**From:** Jeff Tarling  
**To:** Errico Thomas; Jean Fraser  
**CC:** Barbara Barhydt; Caitlin Cameron; David Margolis-Pineo  
**Date:** 7/2/2015 4:09 PM  
**Subject:** Re: Fwd: 2970 Bangor Savings - Marginal Way  
**Attachments:** Beachgrass.JPG; BGisland.JPG

The proposed 2970 Bangor Savings Bank landscape plan for Marginal Way is acceptable with the condition that ONE tree is planted in the rear right side traffic island and vegetation is added to the proposed rear curbing area.

Drawing No. **L101**

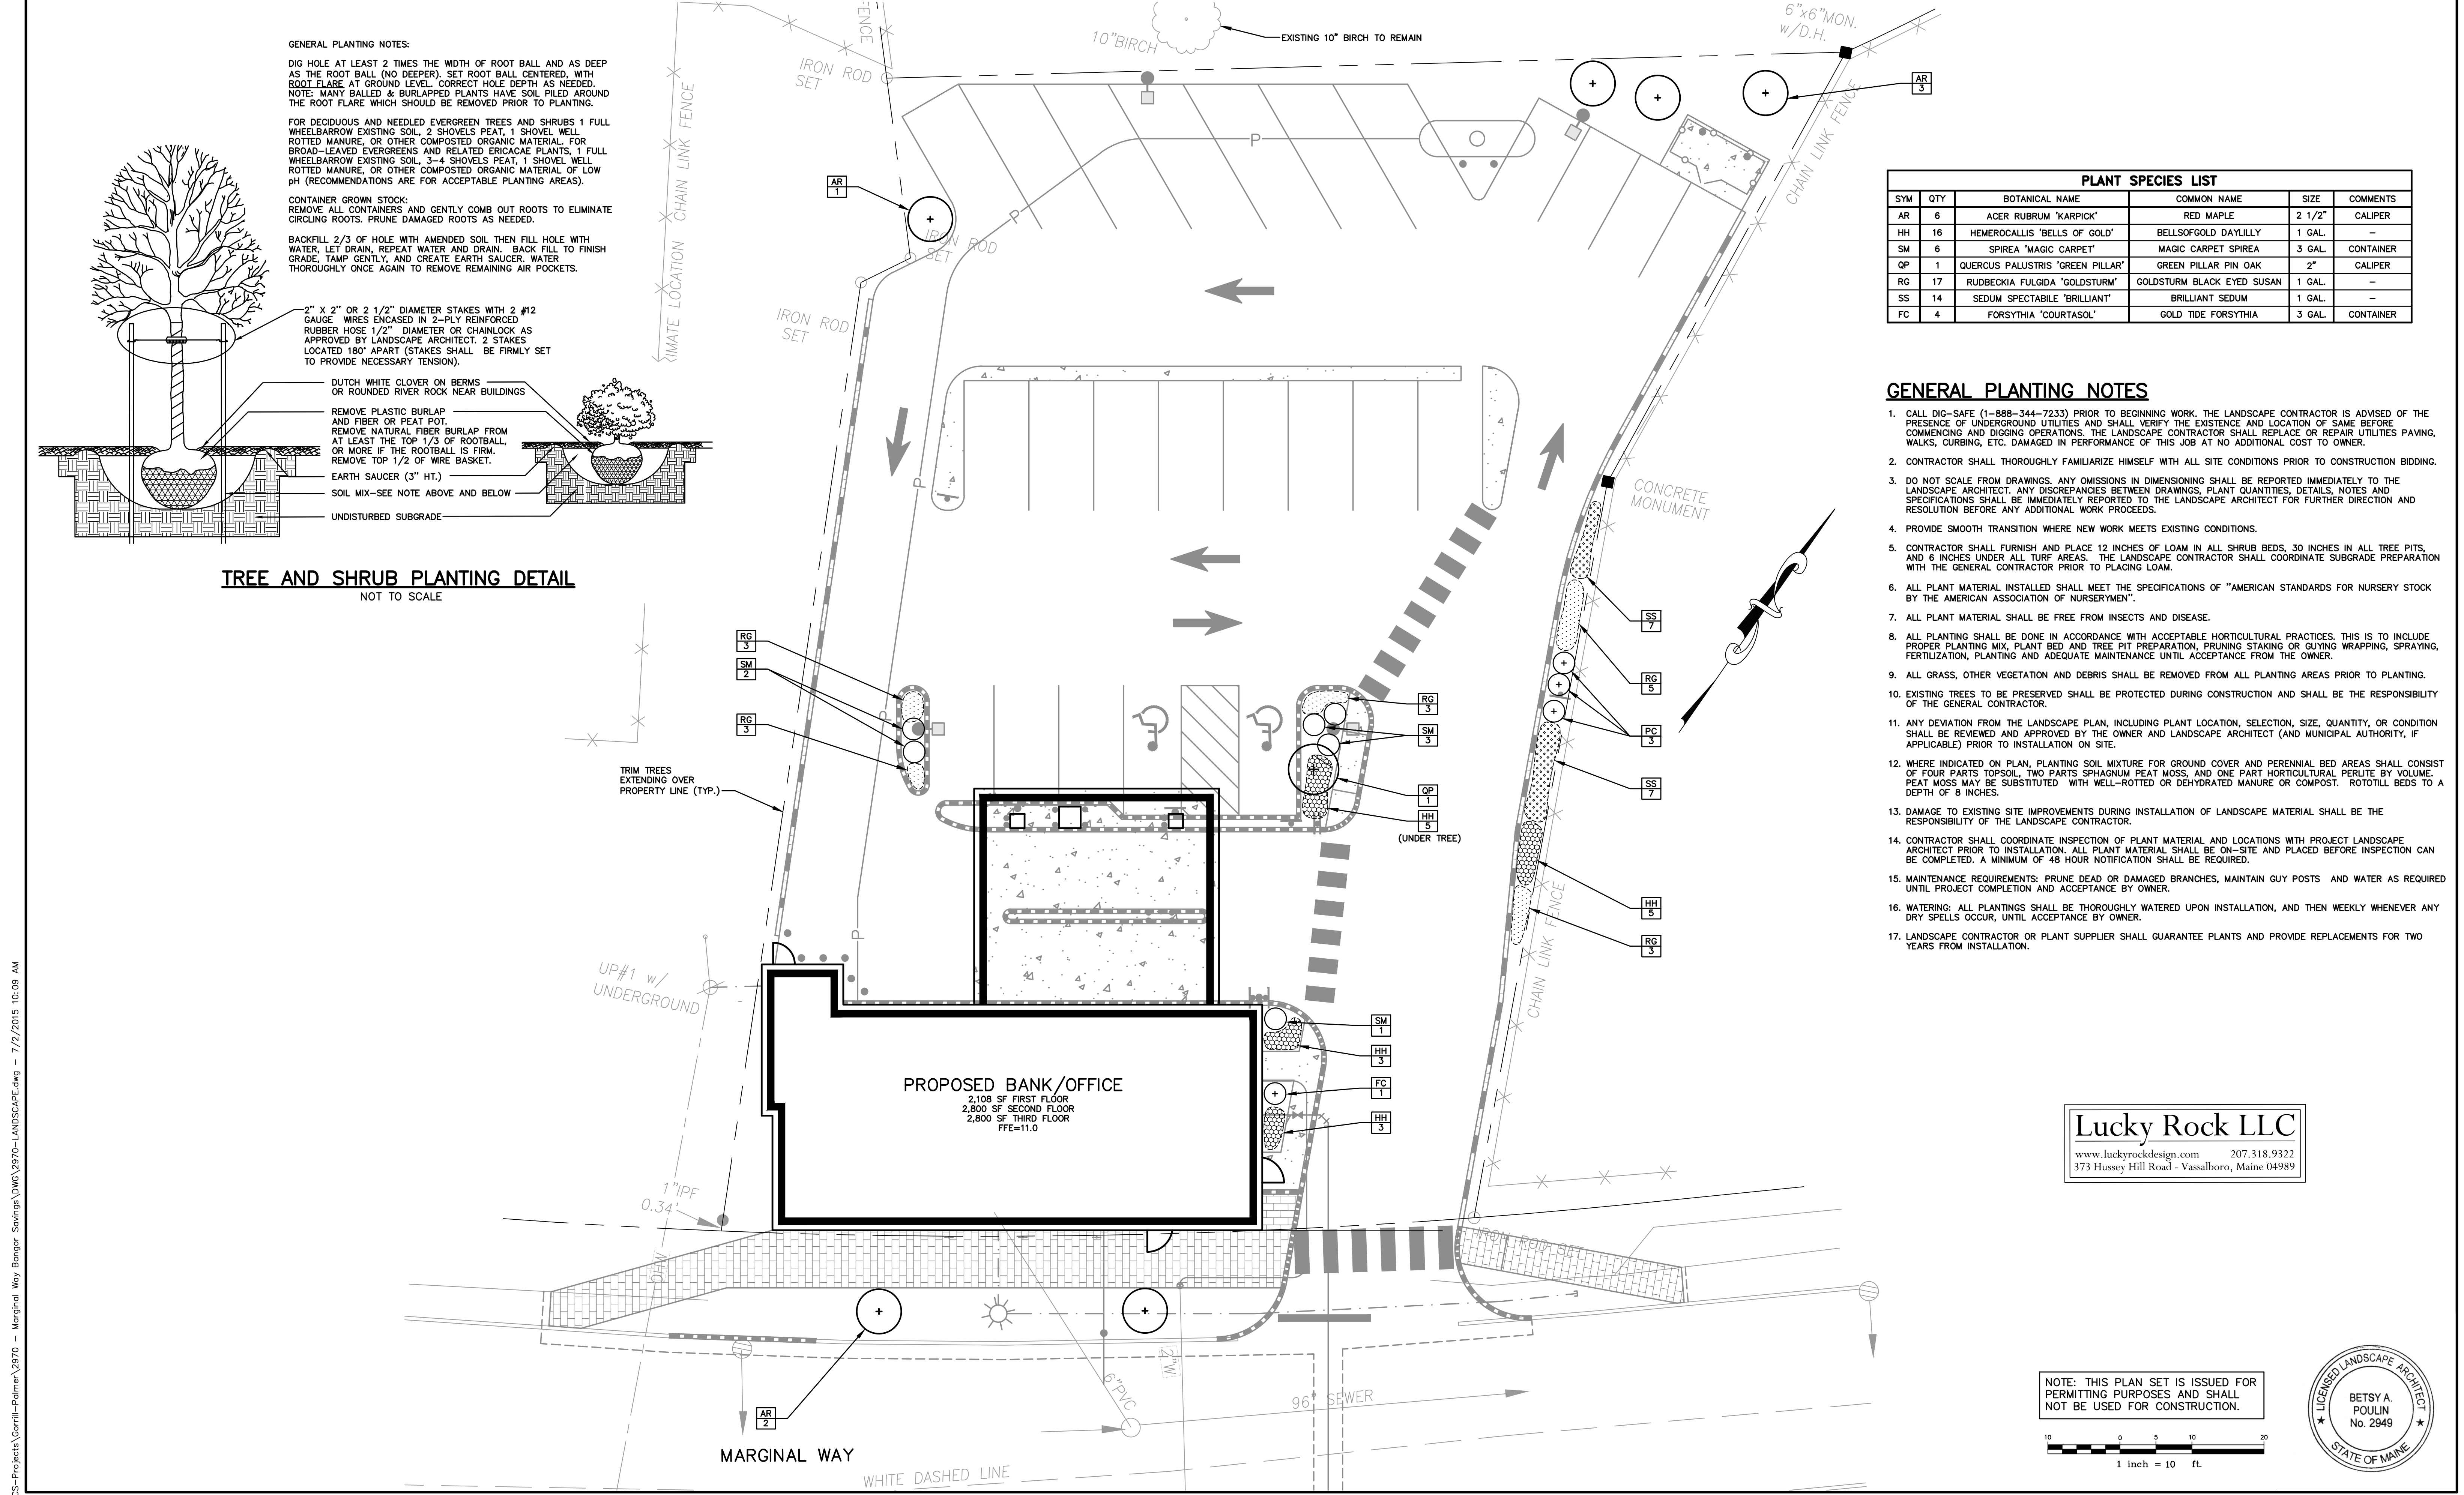
The attached photos demonstrate that ornamental grasses can grow in restricted spaces, this is an MDOT project called Hags Parkway / Route One in Scarborough where they successfully use beach grass in a high salt area with good results. The overall Bangor Savings Bank project has much less than average landscape percentage due to lot orientation and circulation patterns, however a simple planting of low maintenance beach grass would work, thus is a recommended condition of approval.
